THE COTTAGES AT MESA RIDGE GOODWIN KNIGHT EL PASO COUNTY, COLORADO

NOT FOR CONSTRUCTION SHEET L.01 1 PUD DEVELOPMENT PLAN LANDSCAPE COVER SHEET

Landscape Plan drawings_V1 redlines.pdf Markup Summary

NOTES:

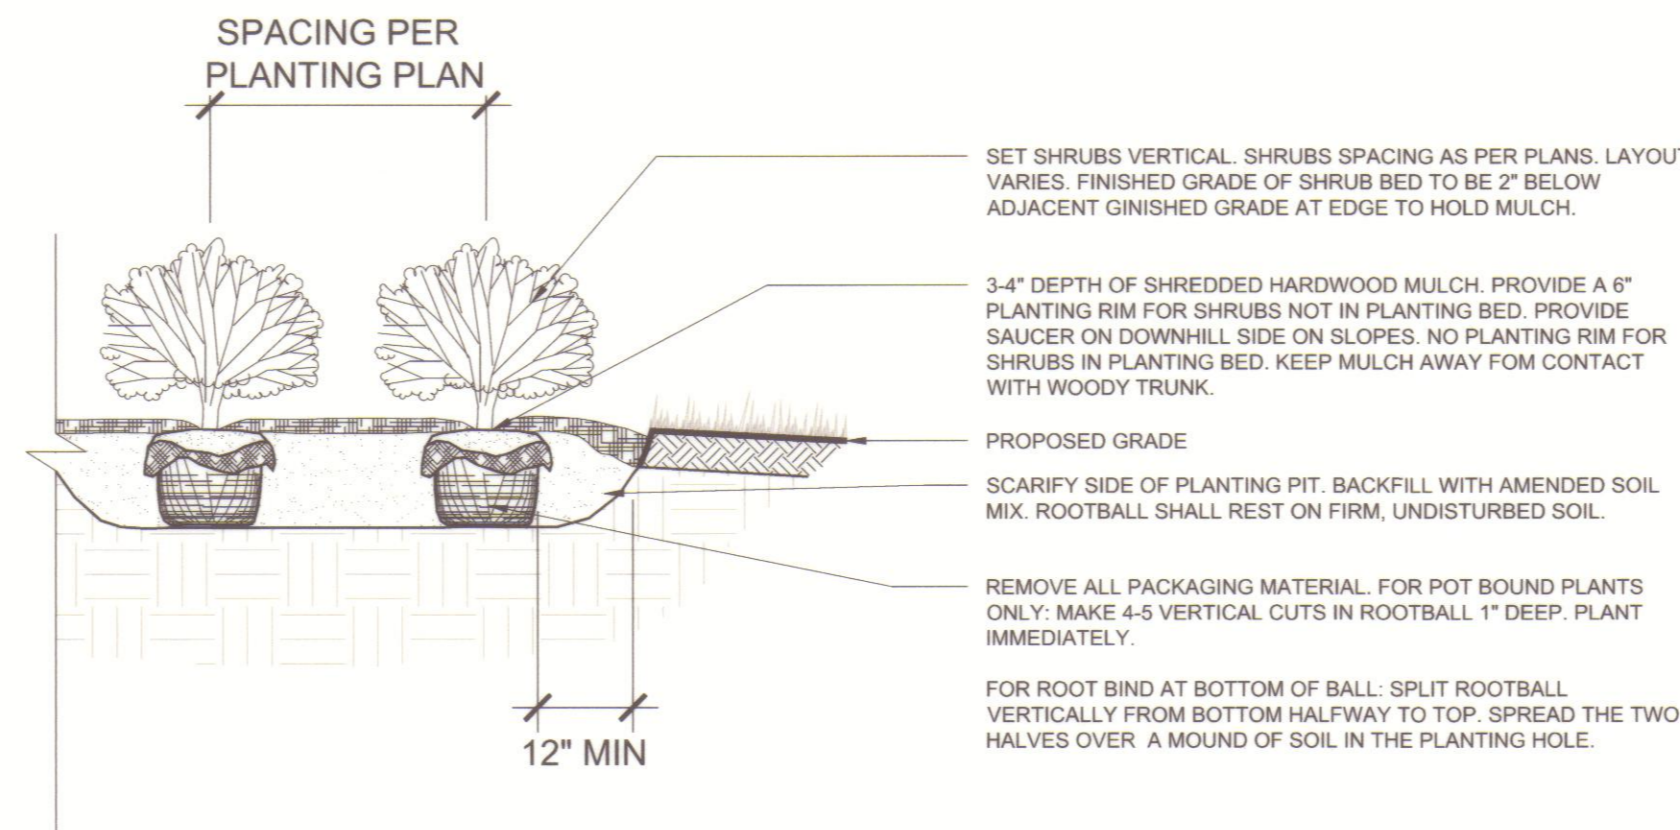
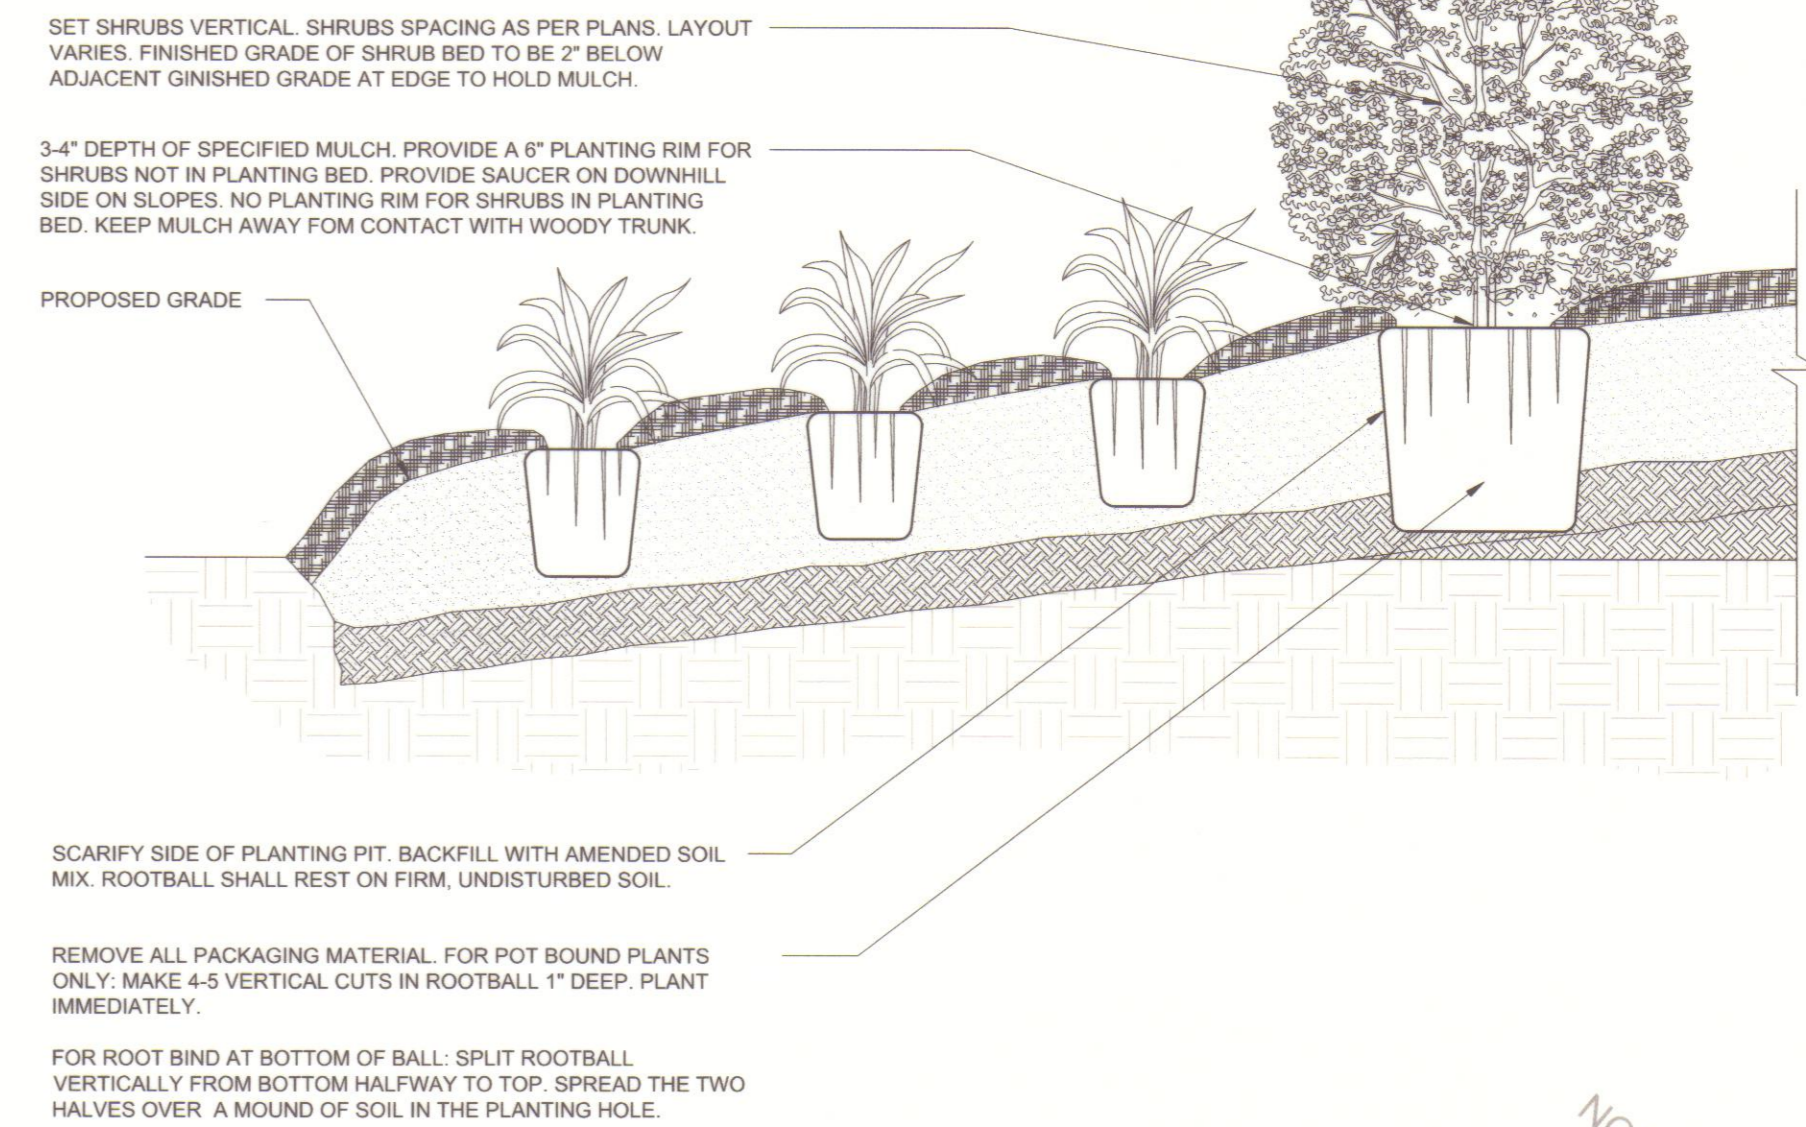
planting details; fencing details;

SHEET
L.08

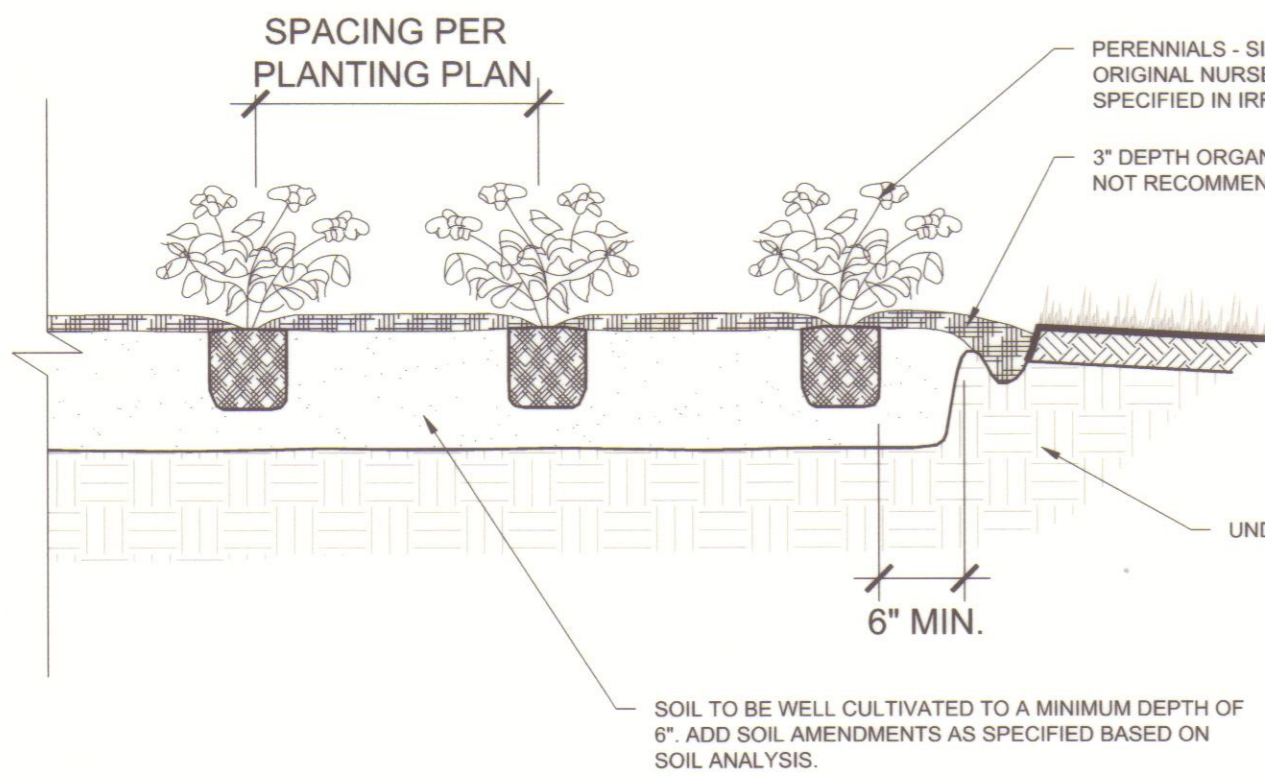
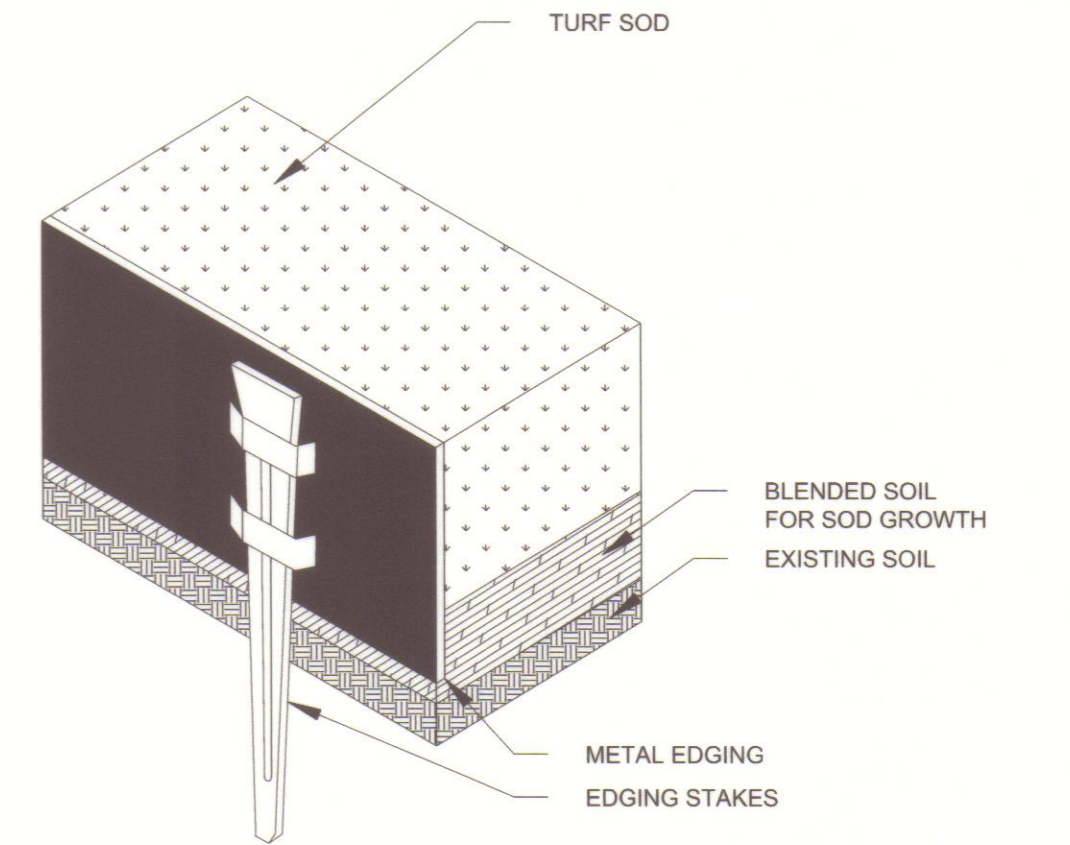
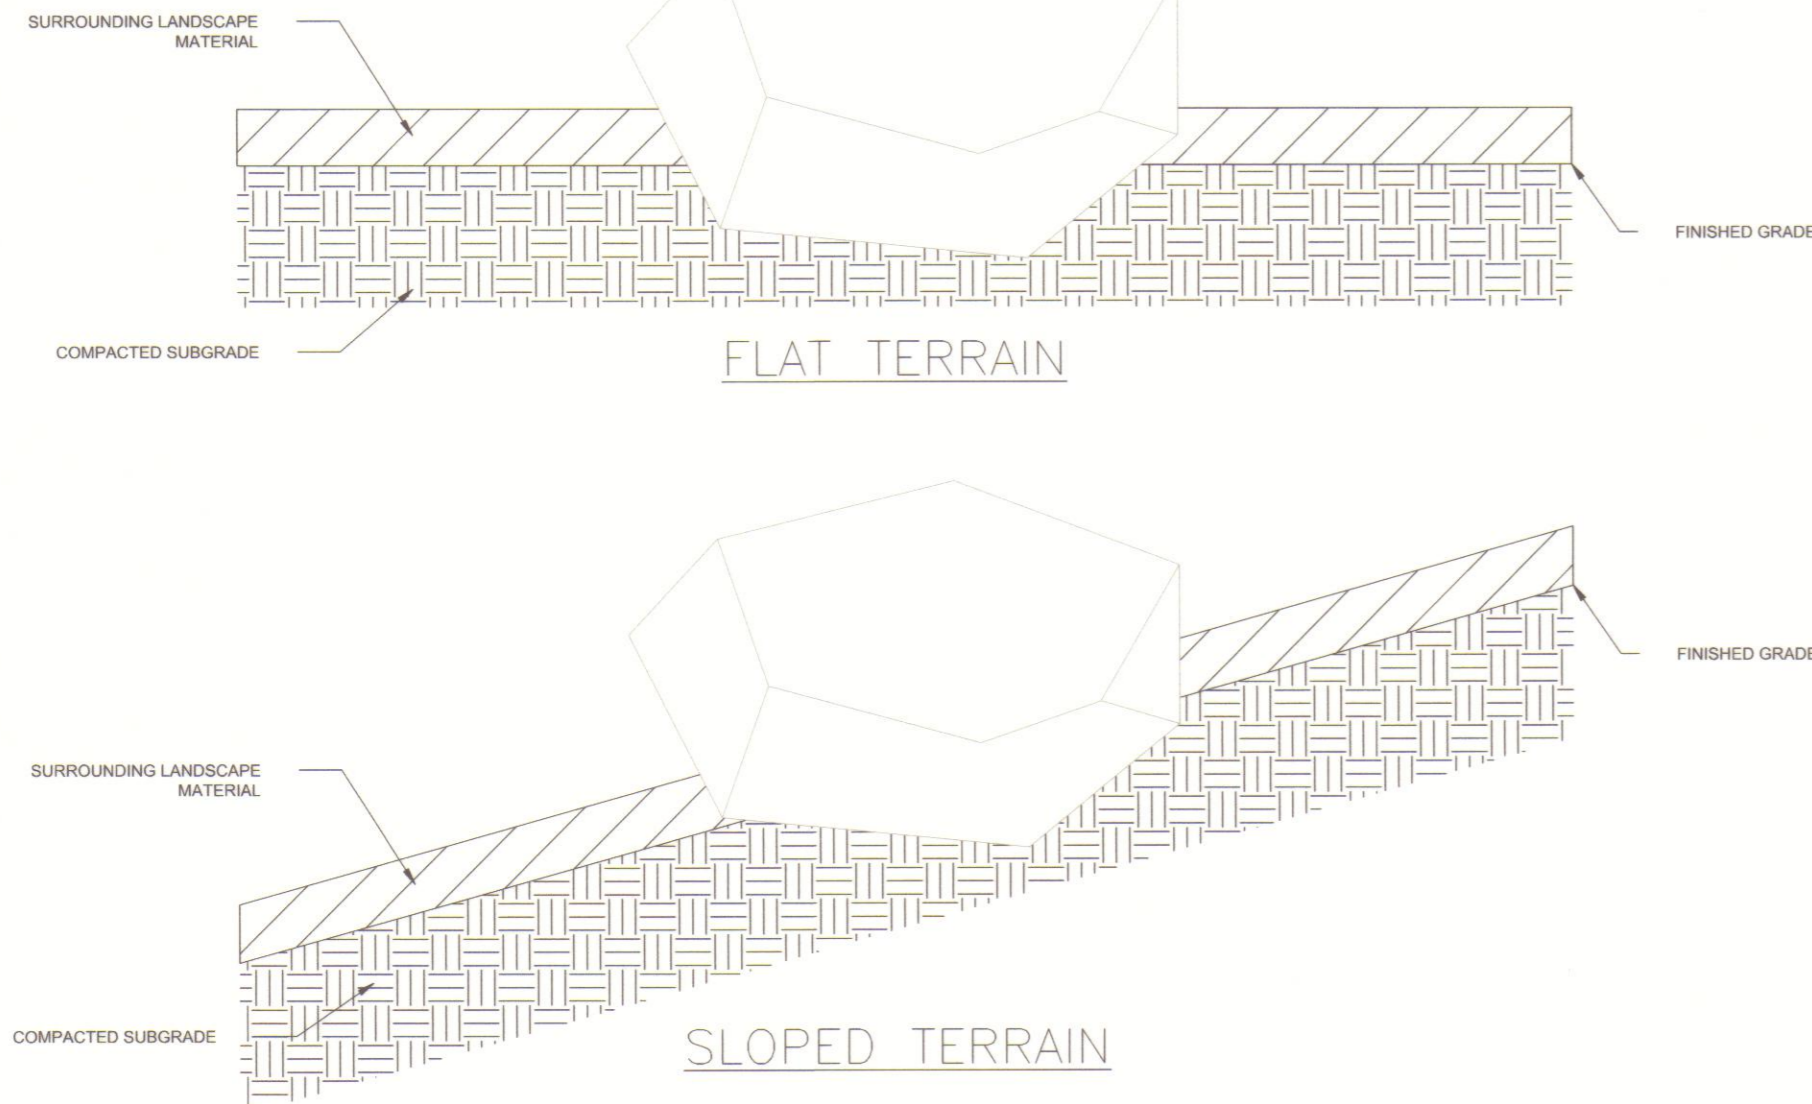
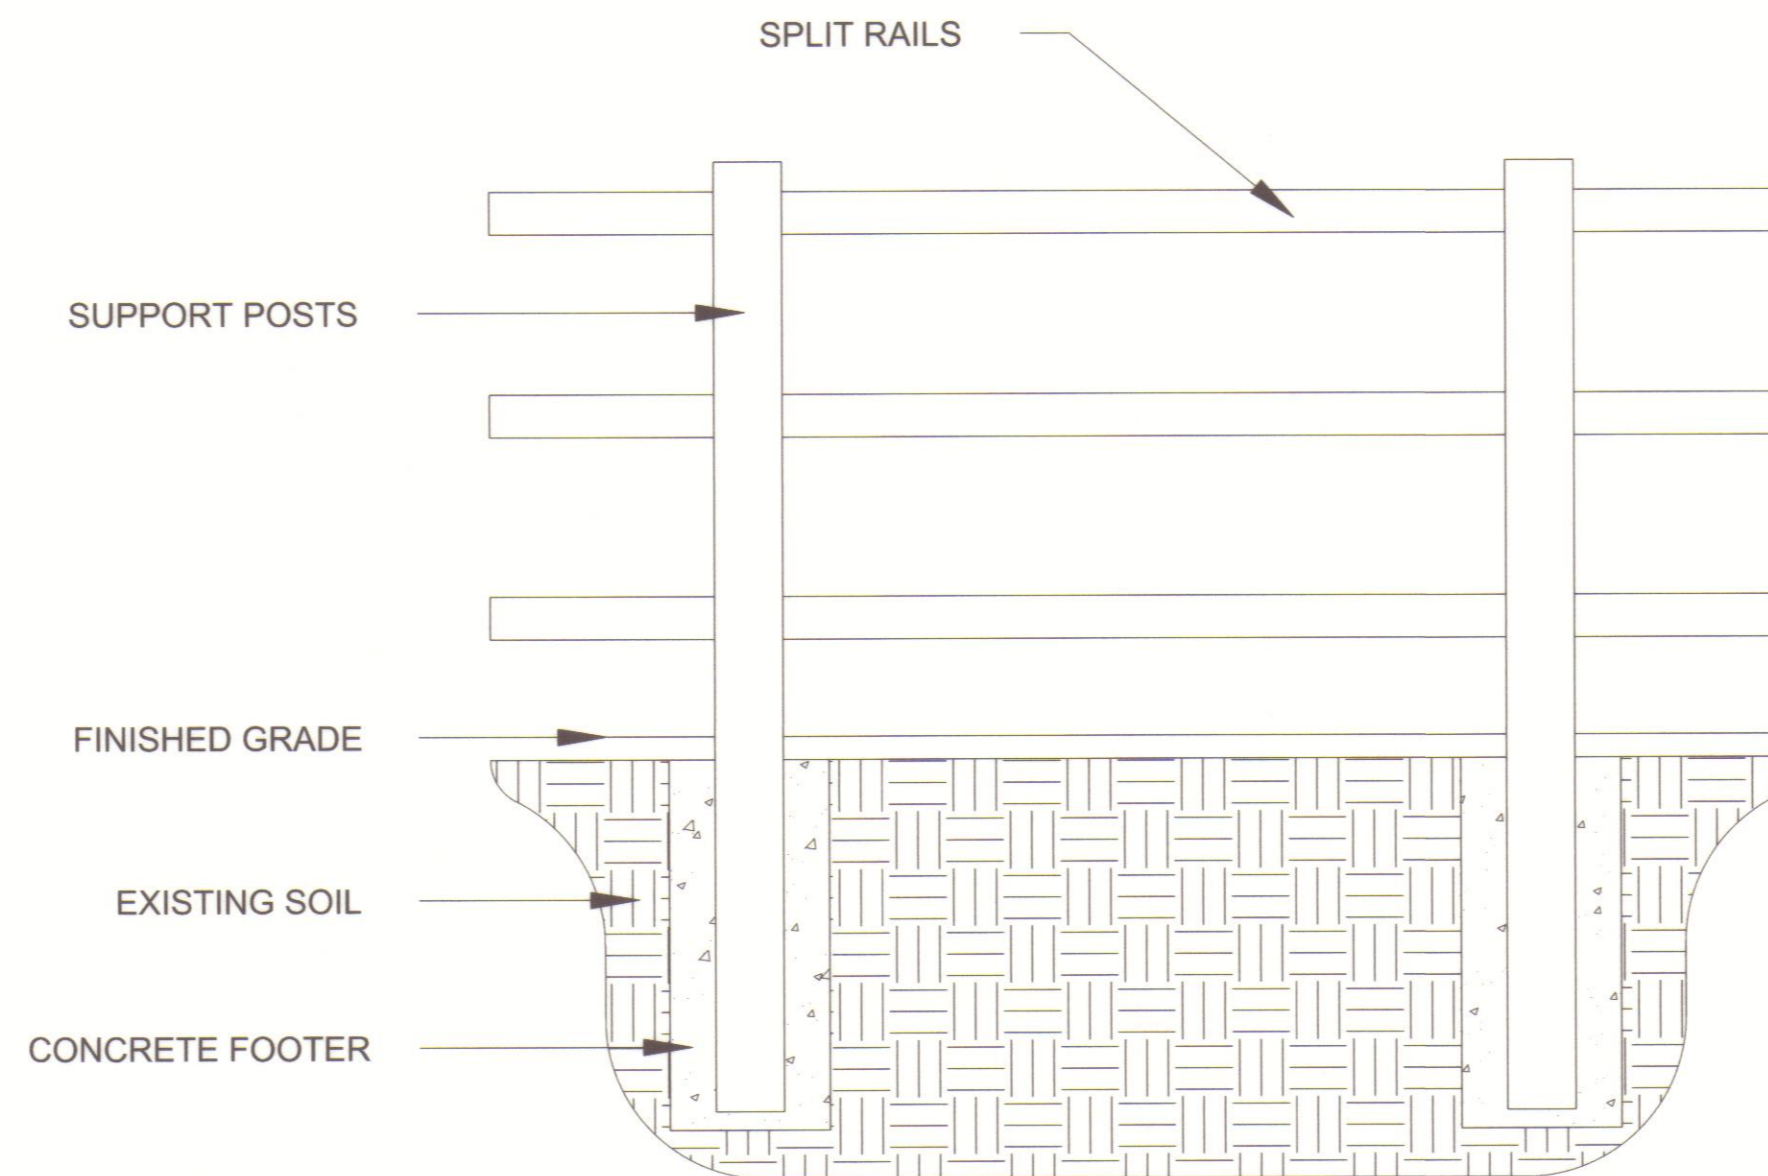
is this a fence? provide detail

trash enclosure detail

provide retaining wall details
